# CITY OF PORTLAND, MAINE

Project Name:	Nineteen-Unit Condominium	Project ID:	2017-073, 2017-115
Address:	155 Sheridan	CBL:	012 Q012
Applicant:	Bernie Saulnier		
Planner:	Matthew Grooms

RE: Staff Review Comments for 155 Sheridan Street (2017-073) – Planning Board Review

Project Name: 155 Sheridan Street Project ID: (2017-073)  
Project Address: 155 Sheridan Street CBL: 012-Q-012  
Applicant: Will Savage  
Planner: Matthew Grooms

UNDERDRAINED SUB-SURFACE SAND FILTER TYPICAL CROSS SECTION
NOT TO SCALE

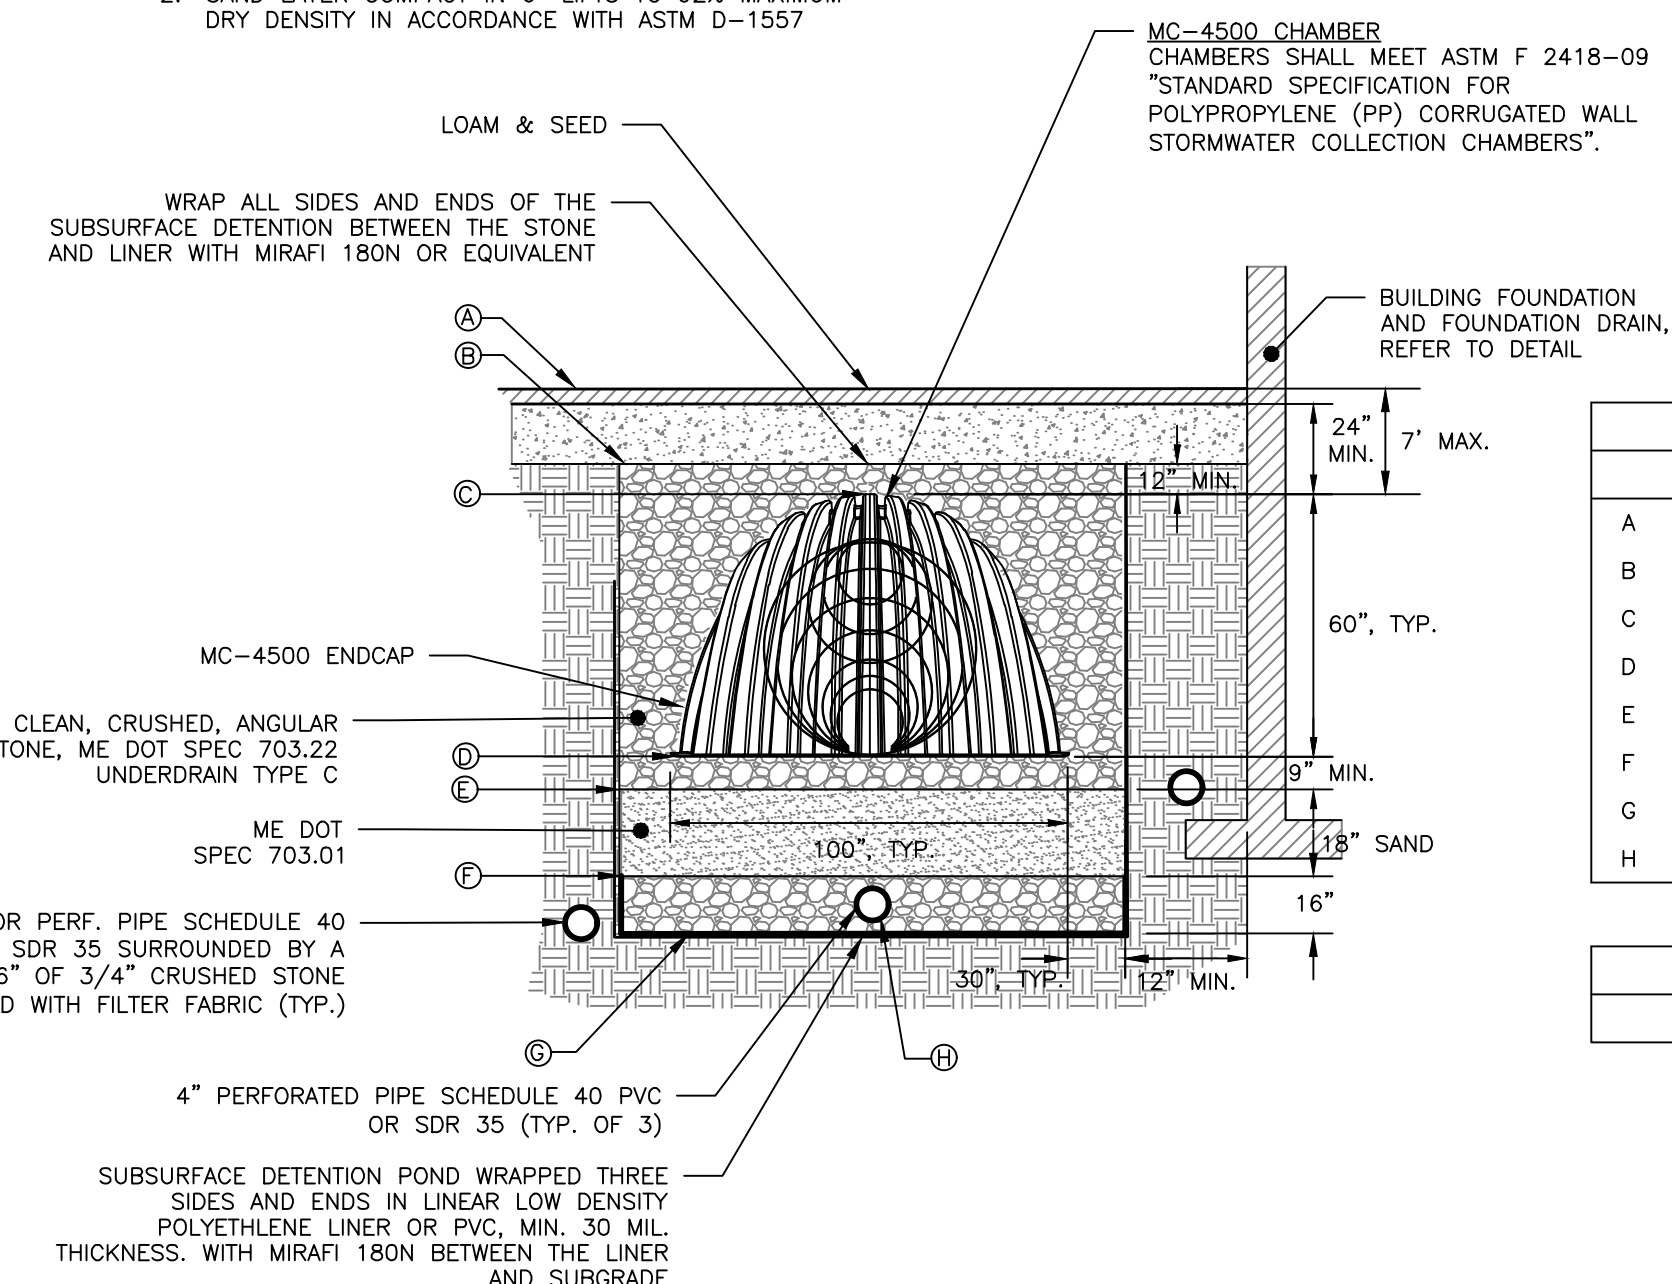
- i. Table 4 in the Stormwater Management Report specifies a provided storage volume for the subsurface sand filter of 1,086 cubic feet, however, the modeled storage for pond 1P is approximately 2,222 cubic feet. Please clarify the intended subsurface filter size.

CITY OF PORTLAND: LOCAL ROAD BITUMINOUS PAVEMENT PROFILE
NOT TO SCALE

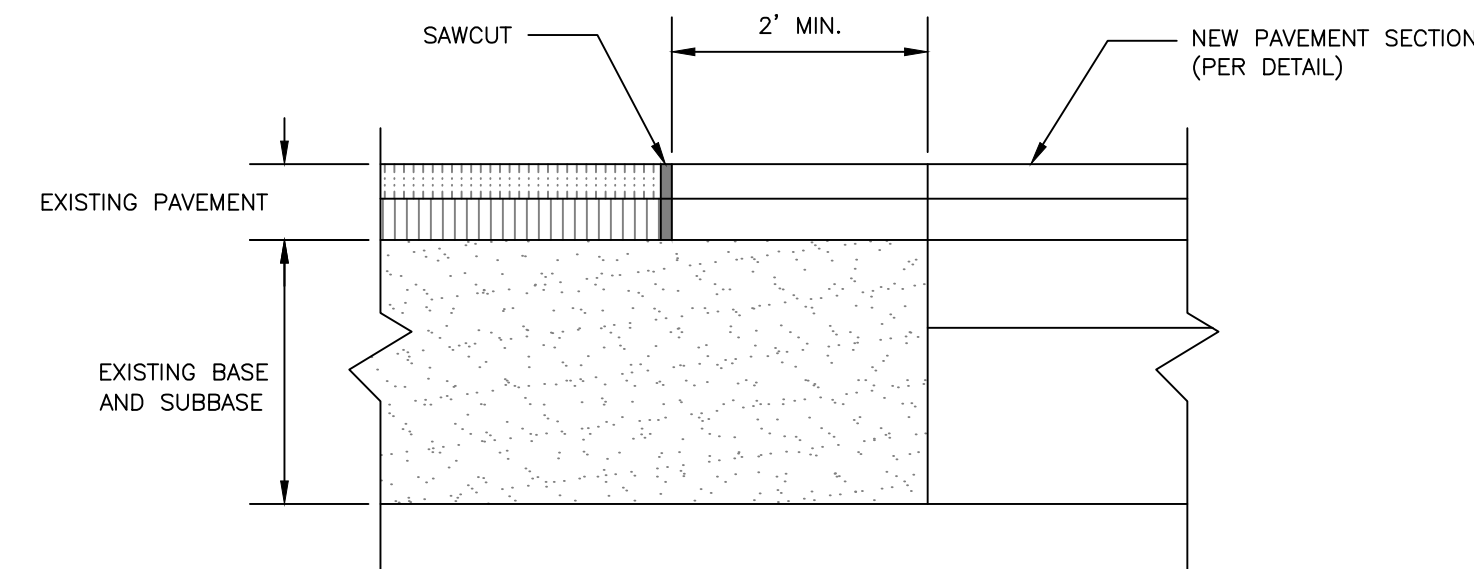
3. The provided bituminous pavement detail references both 9.5 and 12.5 mm HMA as the surface course. City of Portland Technical Standards require the use of 12.5 mm HMA.

ISSUED FOR	BY DATE	
PRELIM. APP.	WHS 3/28/17	
FINAL APP.	WHS 8/4/17	
REVISION	REV. DATE	
DRAWING NAME: PRE-DEVELOPMENT WATERSHED MAP	PROJECT NAME: 155 SHERIDAN STREET	CLIENT: VAZZA REAL ESTATE GROUP BD SHERIDAN, LLC 1266 FURNACE BROOK PARKWAY SUITE 300 QUINCY, MA 02169

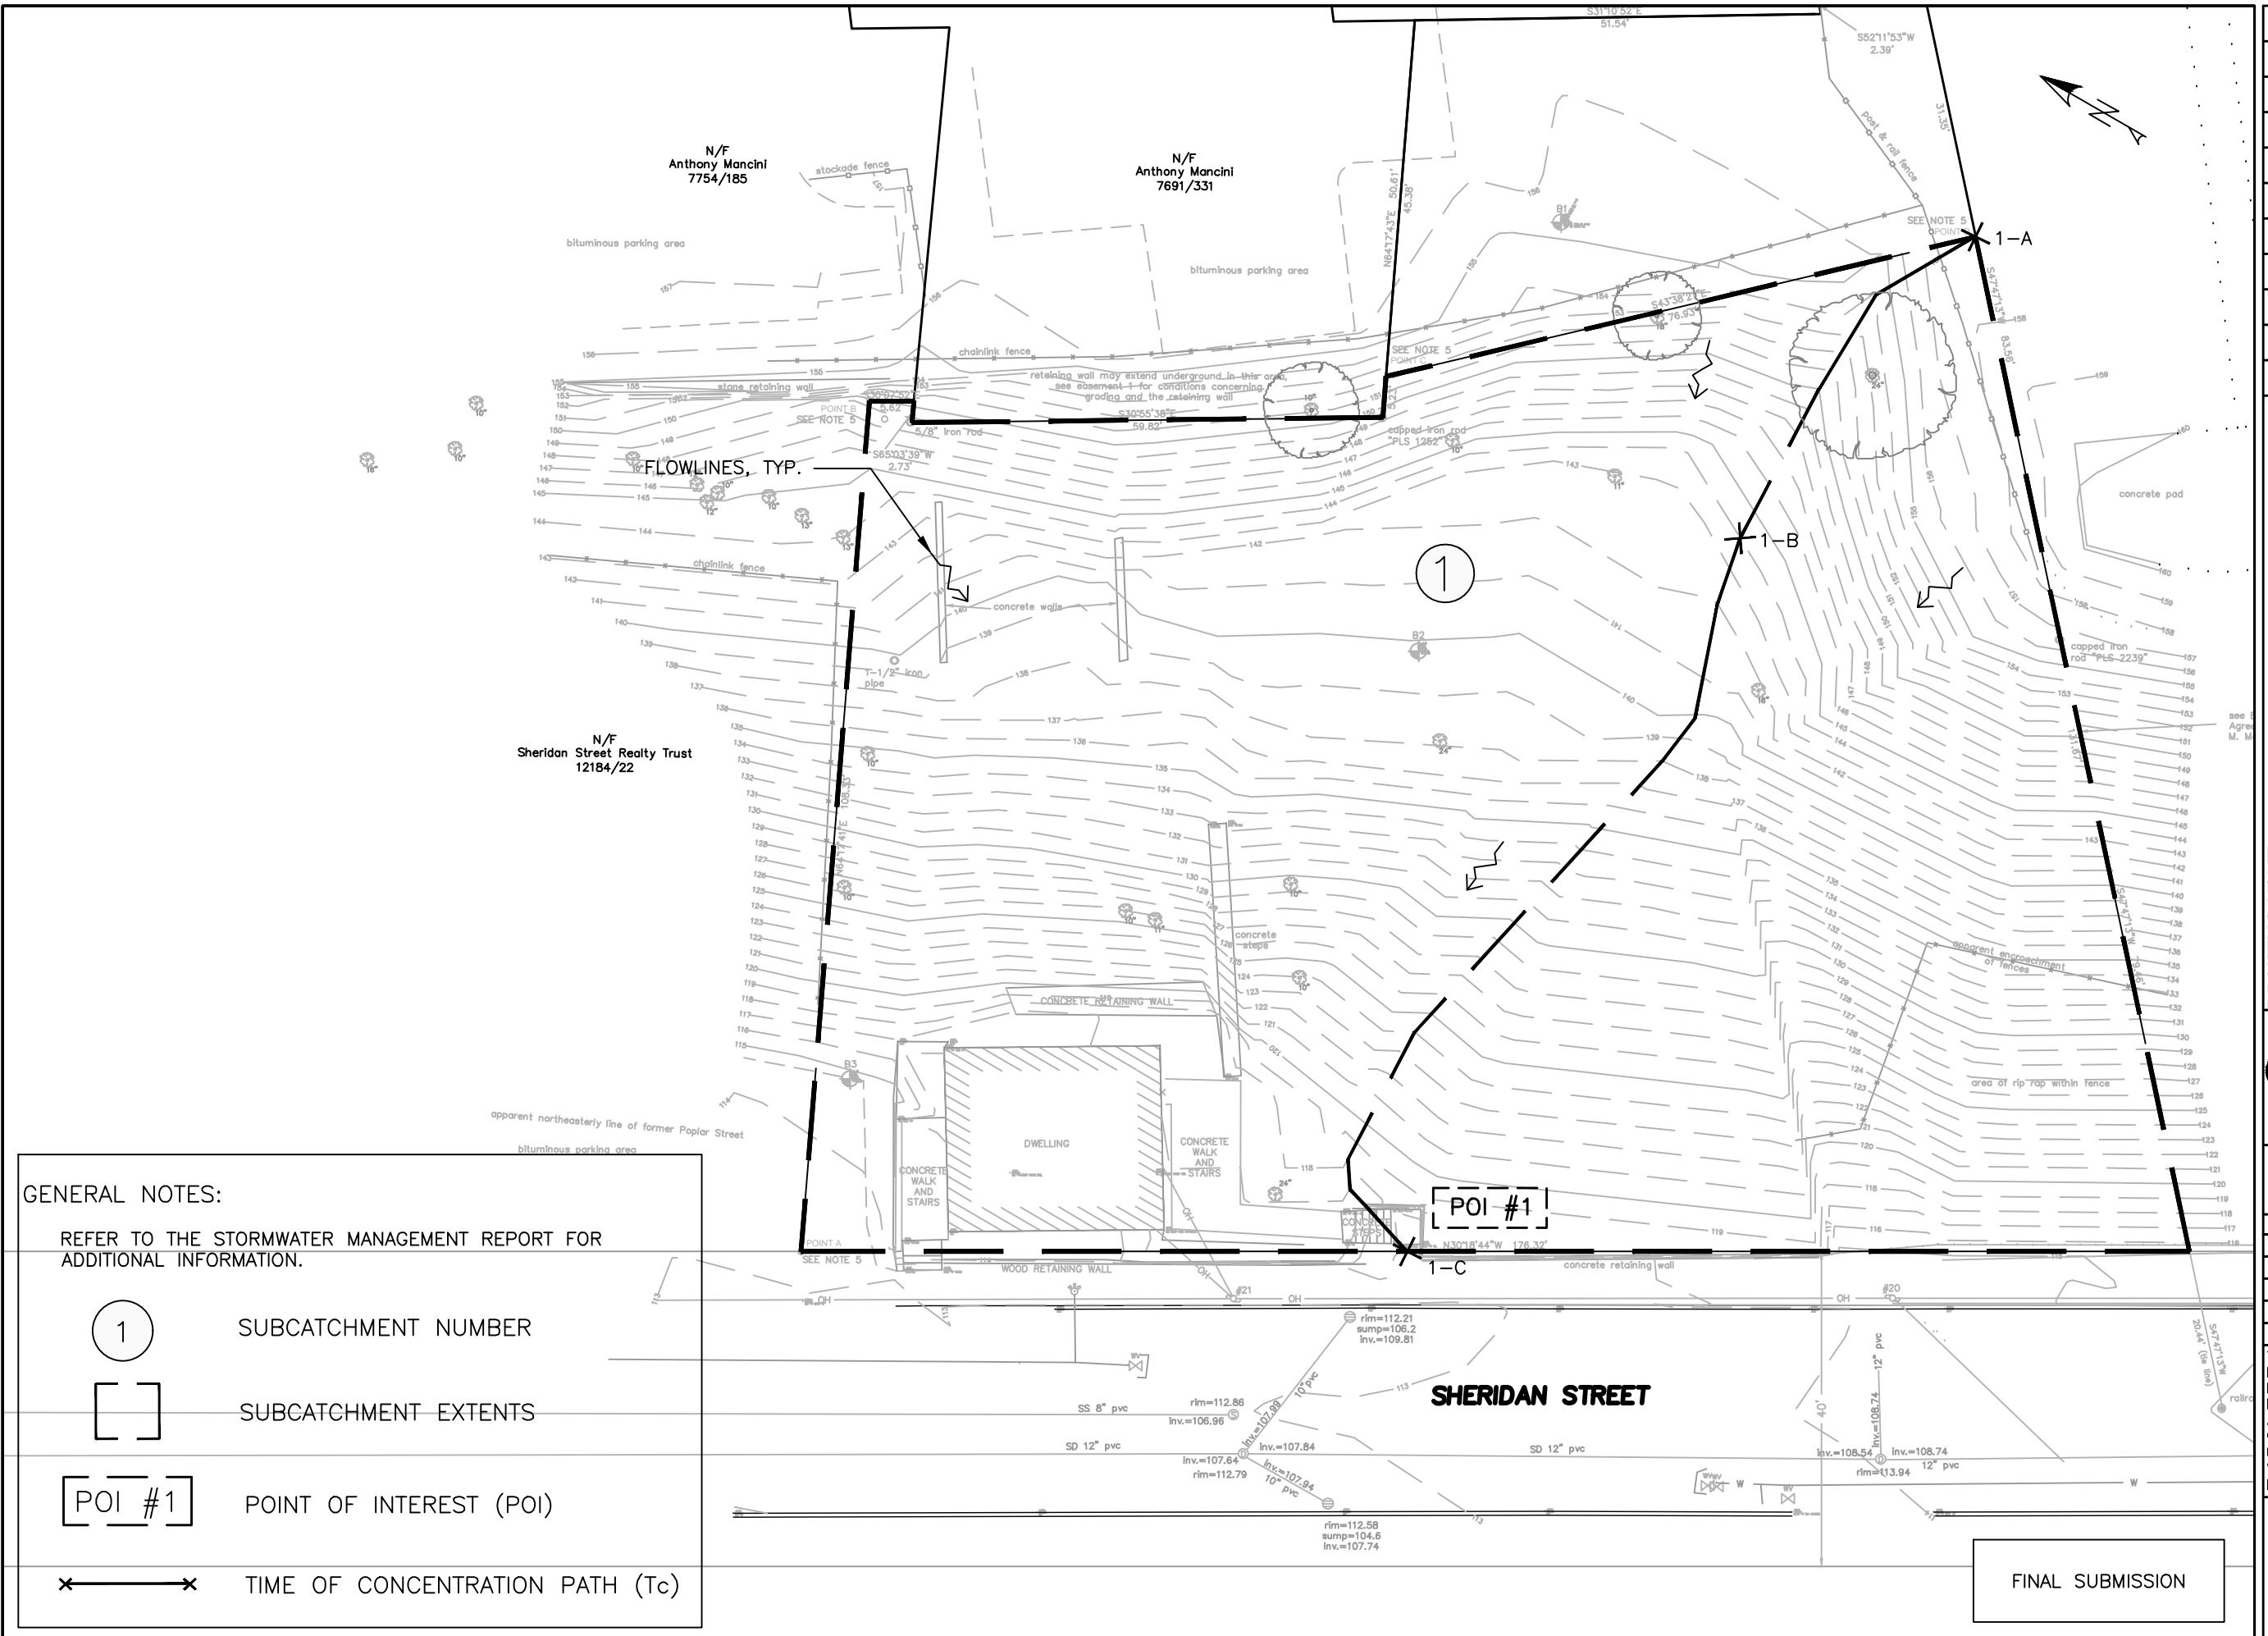
- ii. The Time of Concentration flow path for Pre-Development does not appear to represent the most hydrologically remote point.
    - iii. It appears that a portion of subcatchment 3 shown on the Post-Development watershed, is directed towards the subsurface sand filters and a portion flows directly onto Sheridan Street. Please clarify how flow from the rear of the lot is directed way from the proposed subsurface sand filters.
